Lime Down

Solar Park

Written Summary of the Applicant's Oral Submissions and Responses at Issue Specific Hearing 3 and Responses to Action Points

Document Reference: EXAM/9.50

Title:
Figure 13-6 Abnormal Load Routes - Cable Route Corridor

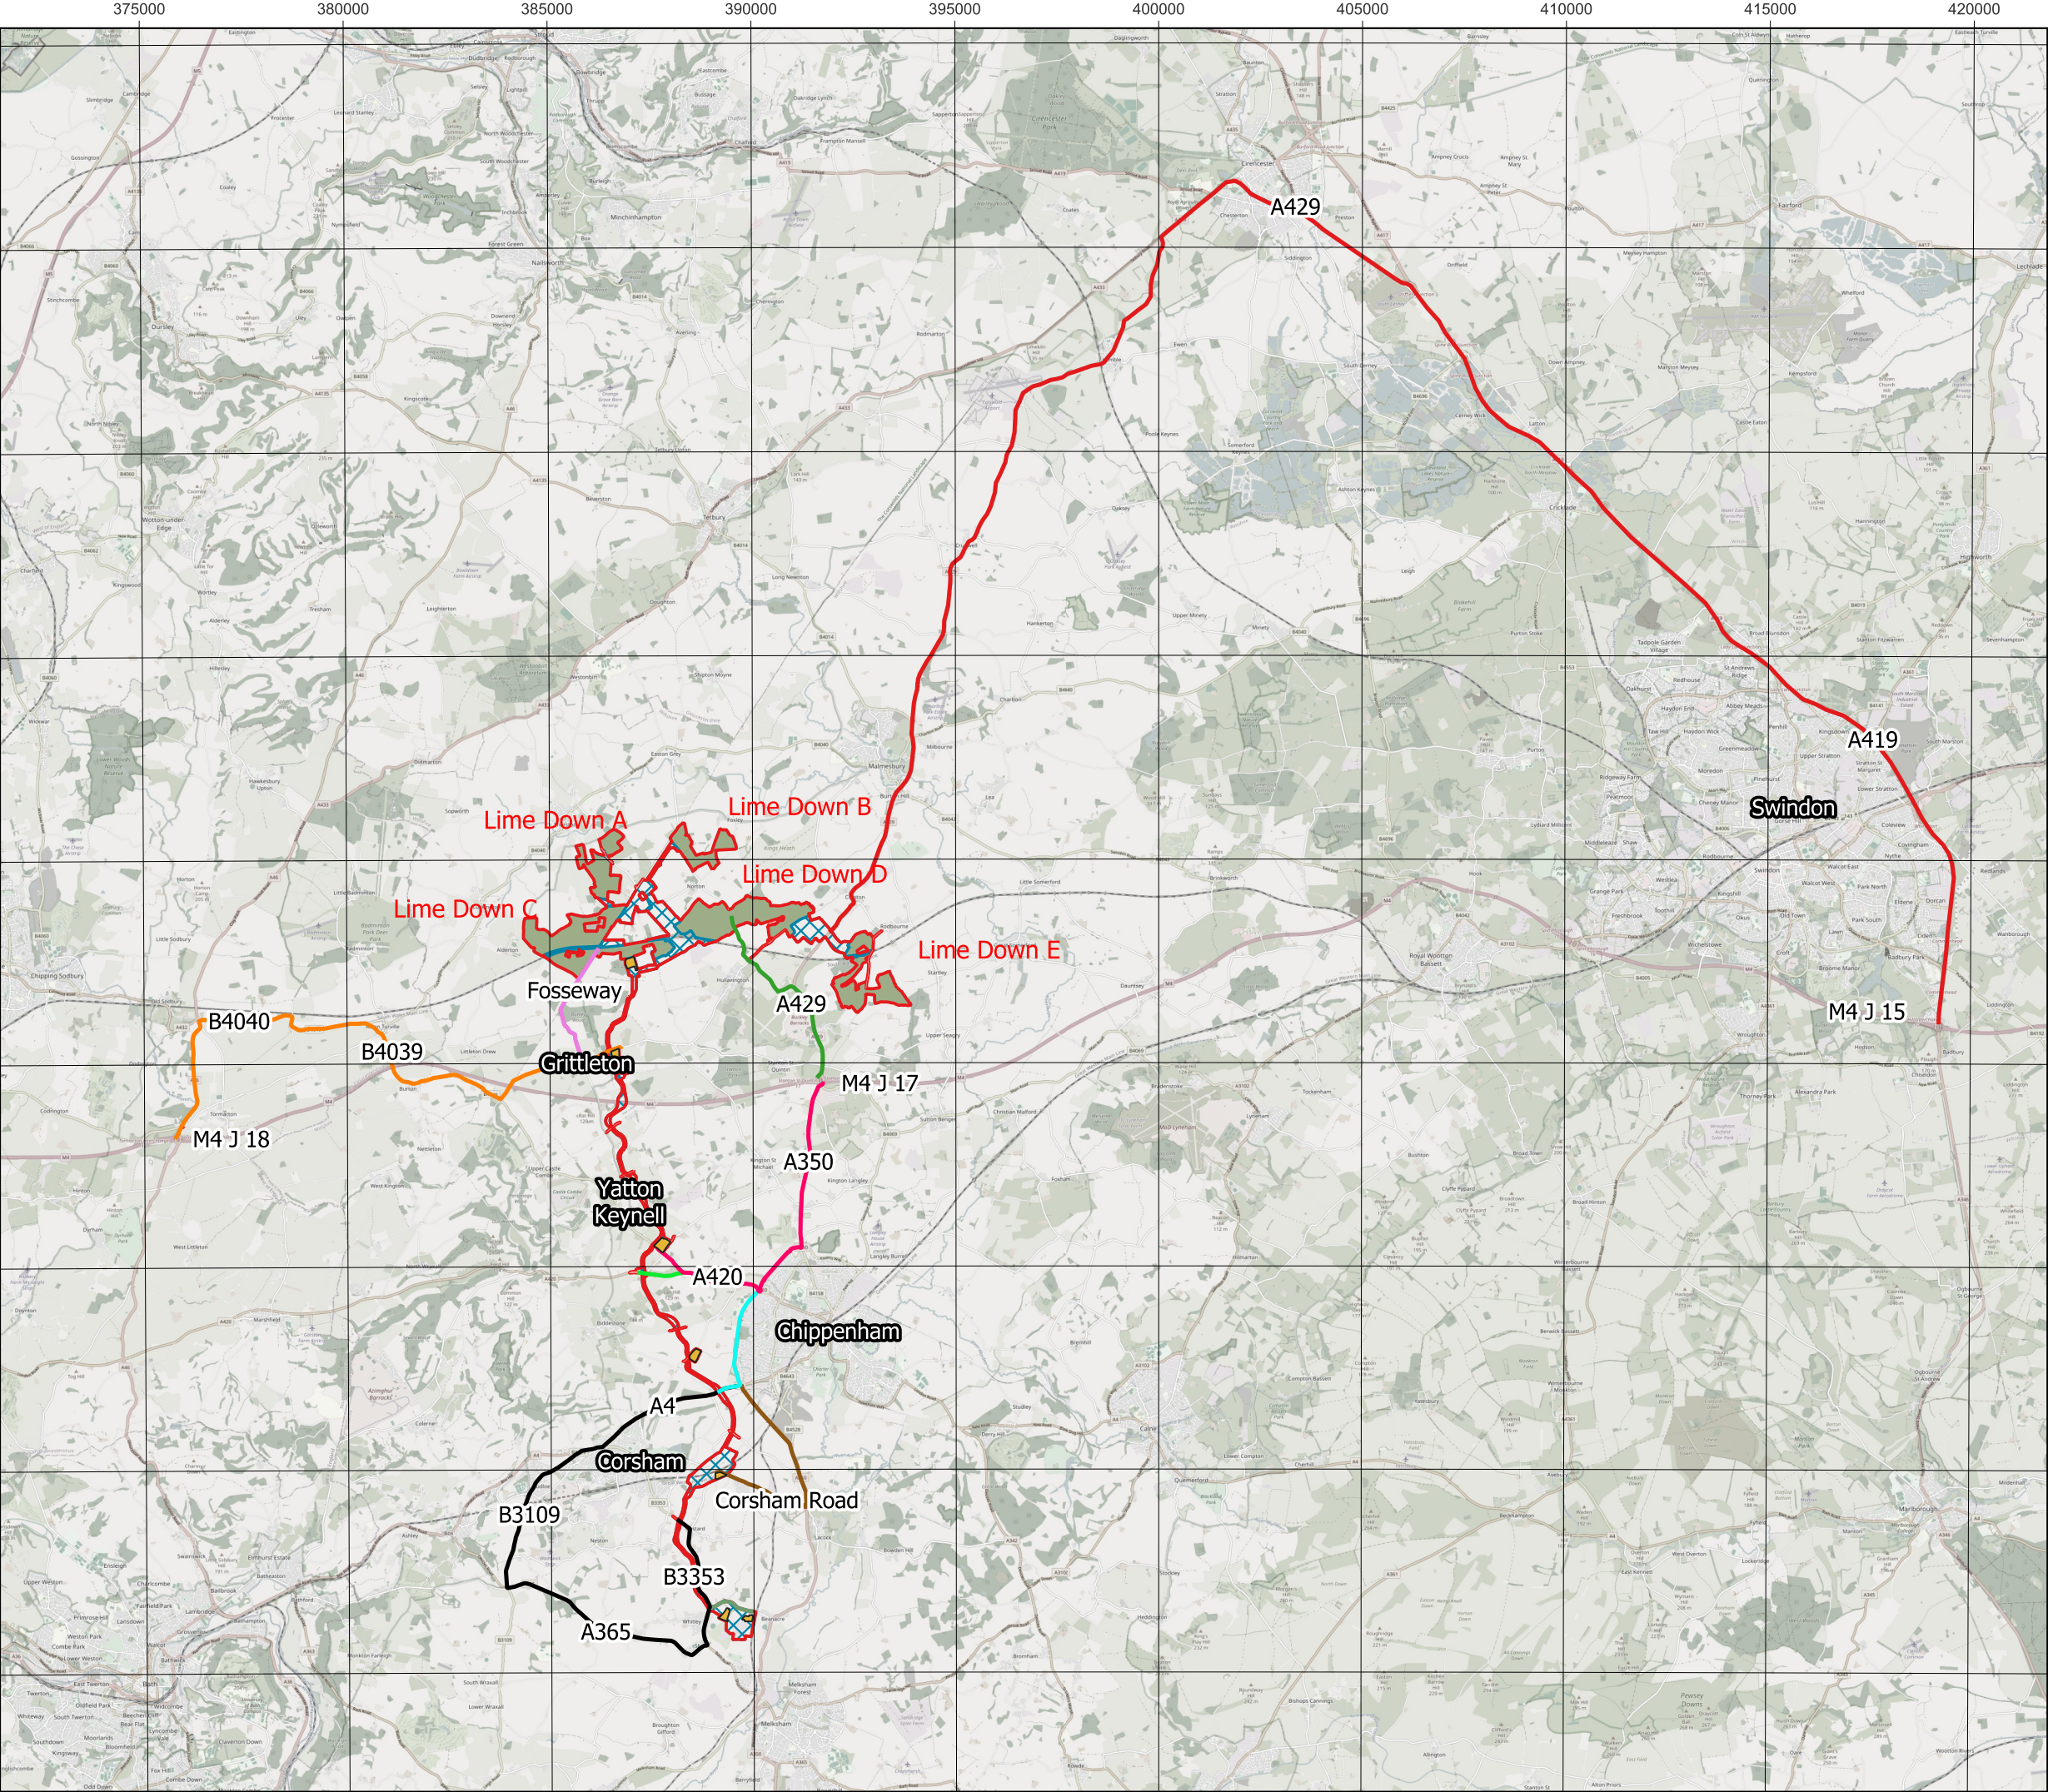
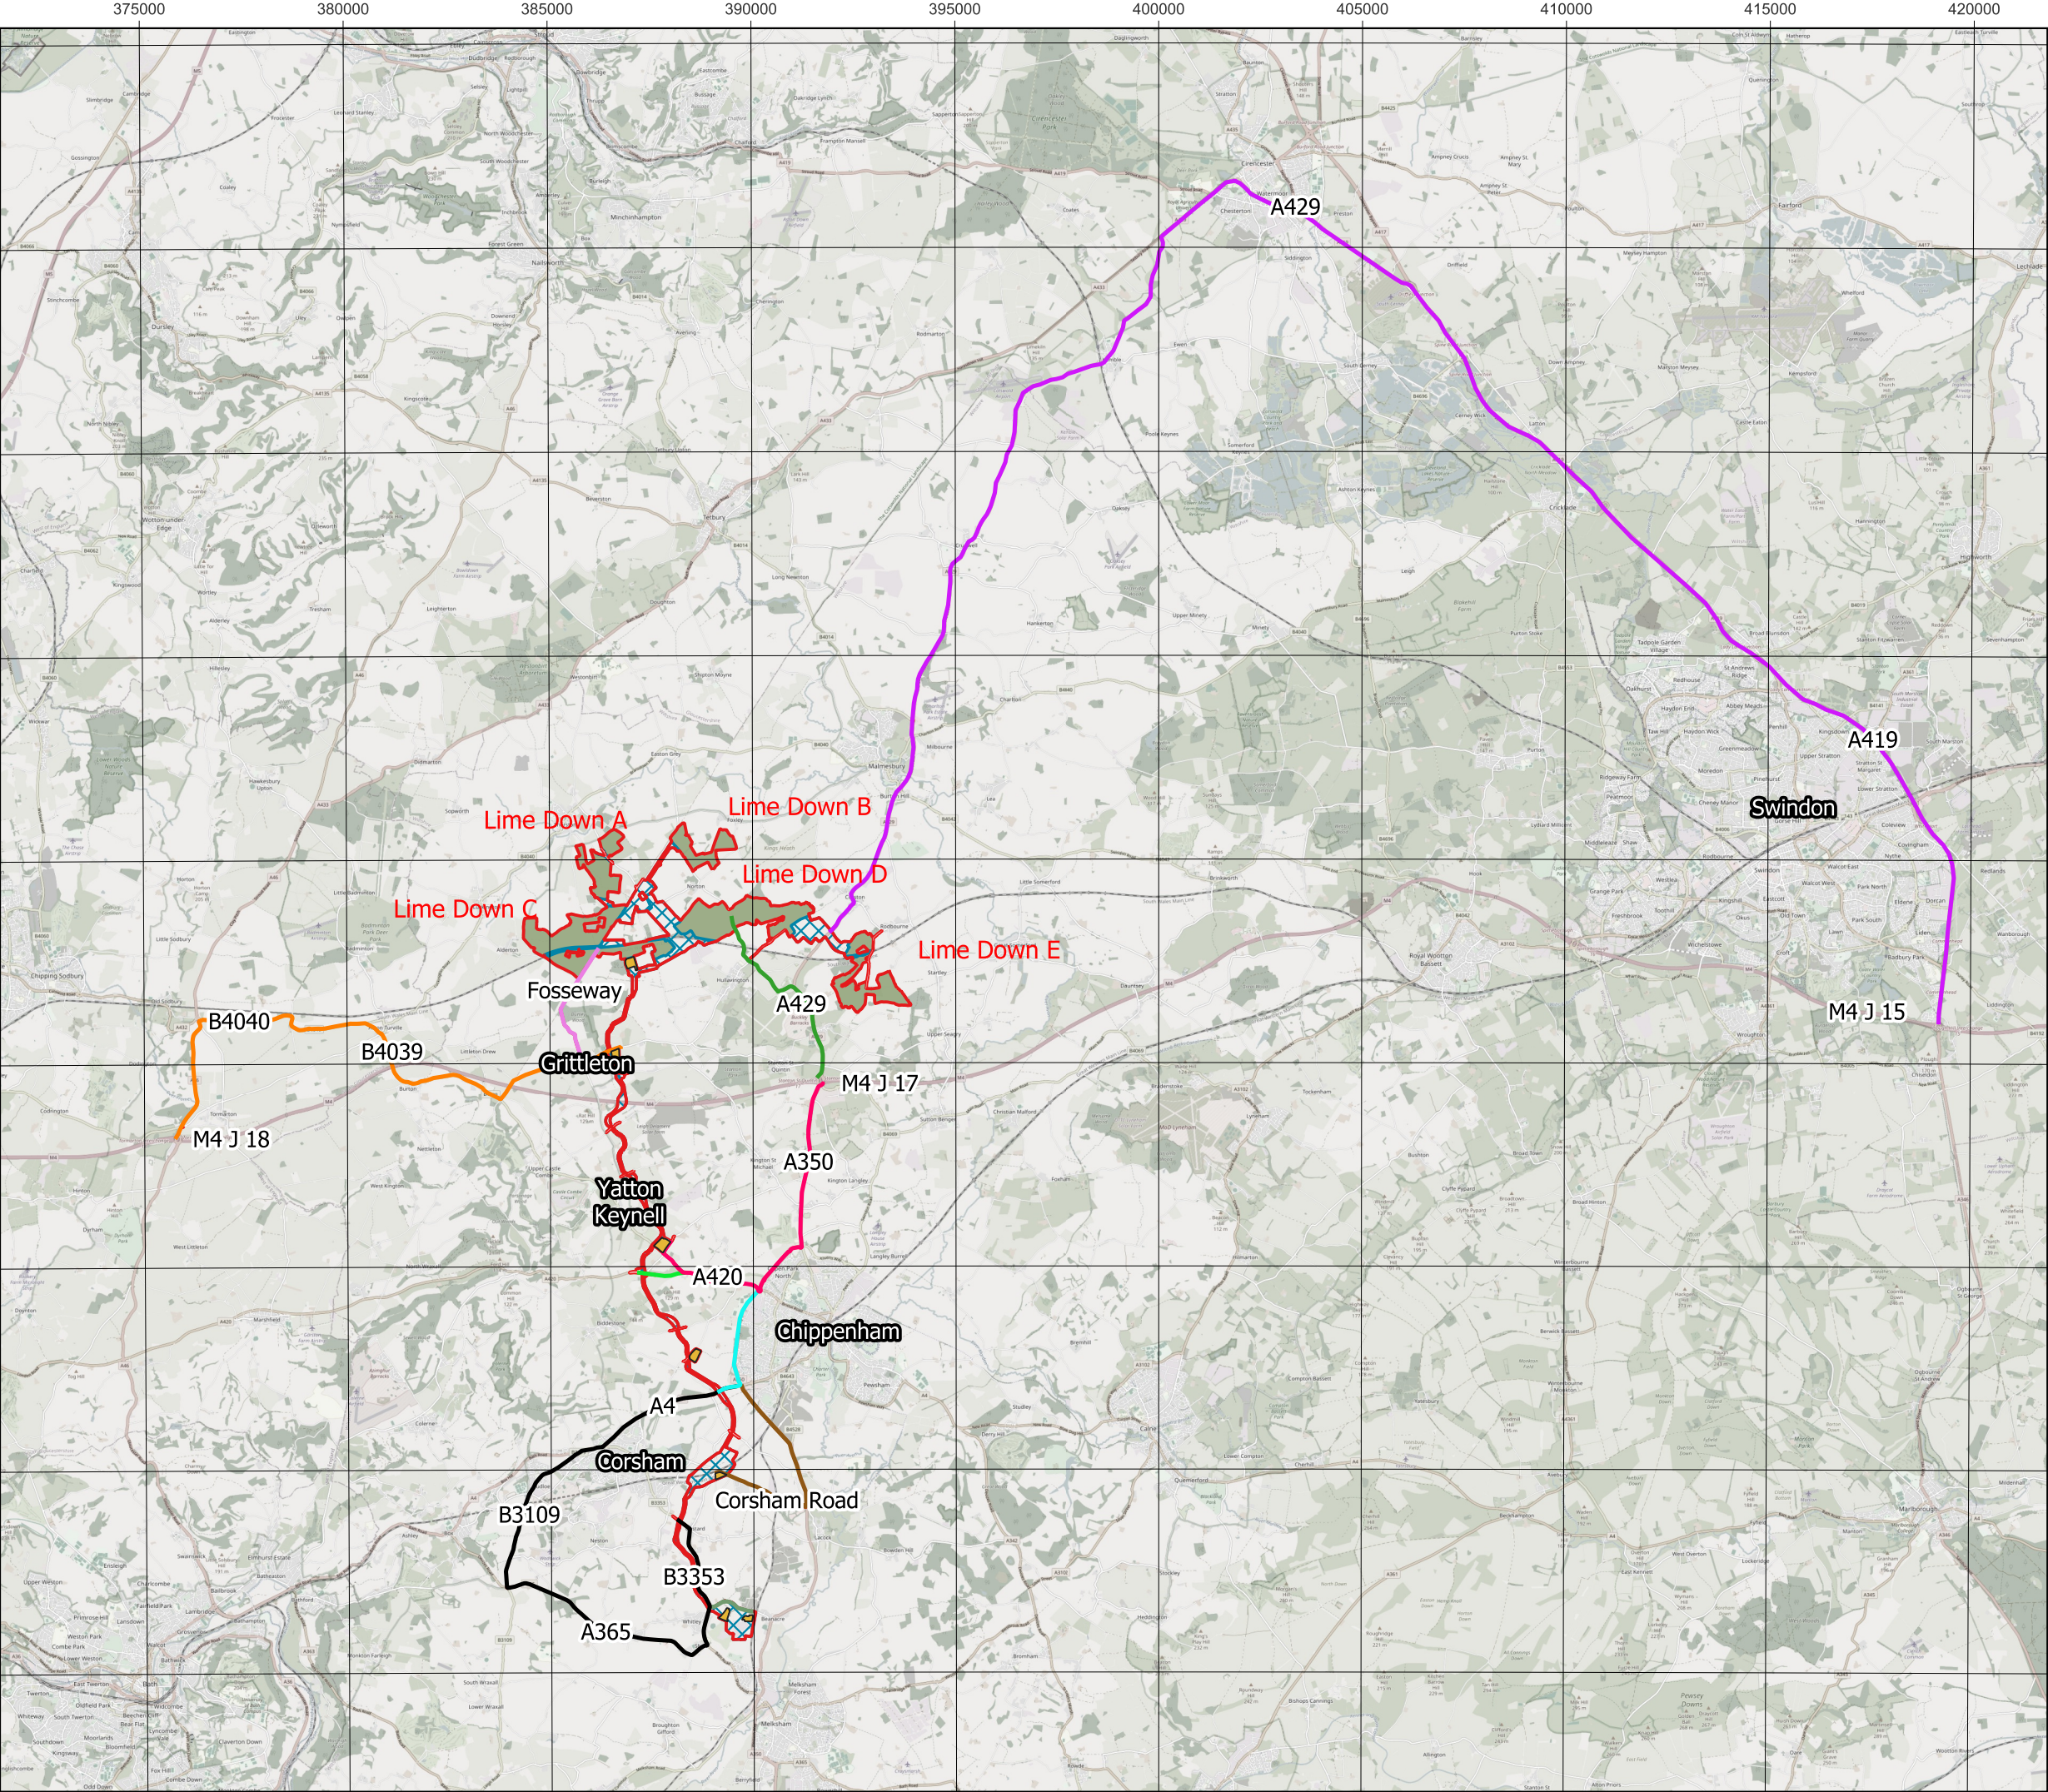
4.	Applicant	Provide a plan to show AIL turning circle at Fowlswick Lane compound to demonstrate the Cable AIL Route 2 will not proceed northwards through Yatton Keynell. For all other AIL routes, if AIL vehicles are intended to follow their same routes in reverse after unloading, provide information to confirm those	Deadline 4	Addressed in the post hearing note at agenda item 2.1 of this written summary.

Agenda item	Comment
	Mr Darrall confirmed that metal plating or matting would be used in this location, that there would be no other vehicle movements, and that the total available space would be used. The ExA referred to loss of tree cover discussed at the site inspection. Mr Threlfall believed the swept path document would confirm the position there. Ms Chalaby confirmed the notice period is 2 clear working days to the police, with 5 working days required for the authority to check for any structures on the route that would impede passage. Ms Brodrick on behalf of the Applicant confirmed there is no need to remove trees in this area. Reference was made to Rep 3066, the updated transport assessment, page 982, Annex J. The ExA asked about the alternative routes for Lime Down A and C (AIL), specifically whether Yatton Keynell could be an alternative. Mr Darrall referred to the purple route — A350, A420 — noting that AIL access to the north goes via Grittleton but does not go south of the railway line, it only goes as far as the construction compound as Fowlswick Lane. Mr Darrall confirmed the Applicant checked there is sufficient manoeuvring space for an AIL load of that type and that it would submit a plan showing this. <i>Post Hearing Note:</i> <i>The Applicant has provided AIL swept paths ES Volume 3, Appendix 13-1 Transport Assessment [REP3-065]. All AIL swept paths show the AIL vehicle entering and exiting each access. On exit, the cab is unhitched from the front of the trailer and driven to the back of the trailer and hitched up, then drives off in forward gear. A turning area for the whole AIL vehicle and trailer is not required as the AIL trailers are modular. ES Volume 2, Abnormal Load Routes - Solar PV Sites [EN010168/APP/6.2] (Revision 2) and ES Volume 2 Figure 13-6</i>

Agenda item	Comment
	<i>Abnormal Load Routes - Cable Route Corridor [EN010168/APP/6.2] (Revision 2 have been updated and submitted at Deadline 4. The update figures show AIL routing to the cable route compound on Fowlswick Lane.</i> <i>A plan is provided for Fowlswick Lane which is set out in Annex D of ES Volume 3 Appendix 13-1: Transport Assessment [REP3-065] (Drawing PL109B).</i> Mr Bamber on behalf of Stop Lime Down raised the issue of notice periods for AIL, noting a temporary traffic regulation order may be required. Mr Bamber requested the Applicant to confirm information on the process and what steps need to happen. Other road traffic regulations were noted to be covered separately. <i>Post Hearing Note:</i> <i>The process for providing notice and the standard AIL process is now included at paragraph 5.5.2 to 5.5.3 in ES Volume 3, Appendix 13-1: Transport Assessment [EN010168/APP/7.22] (Revision 4) and at paragraph 1.7.17 to 1.7.18 of the Outline CTMP [EN010168/APP/7.22] (Revision 4) submitted at Deadline 4.</i>
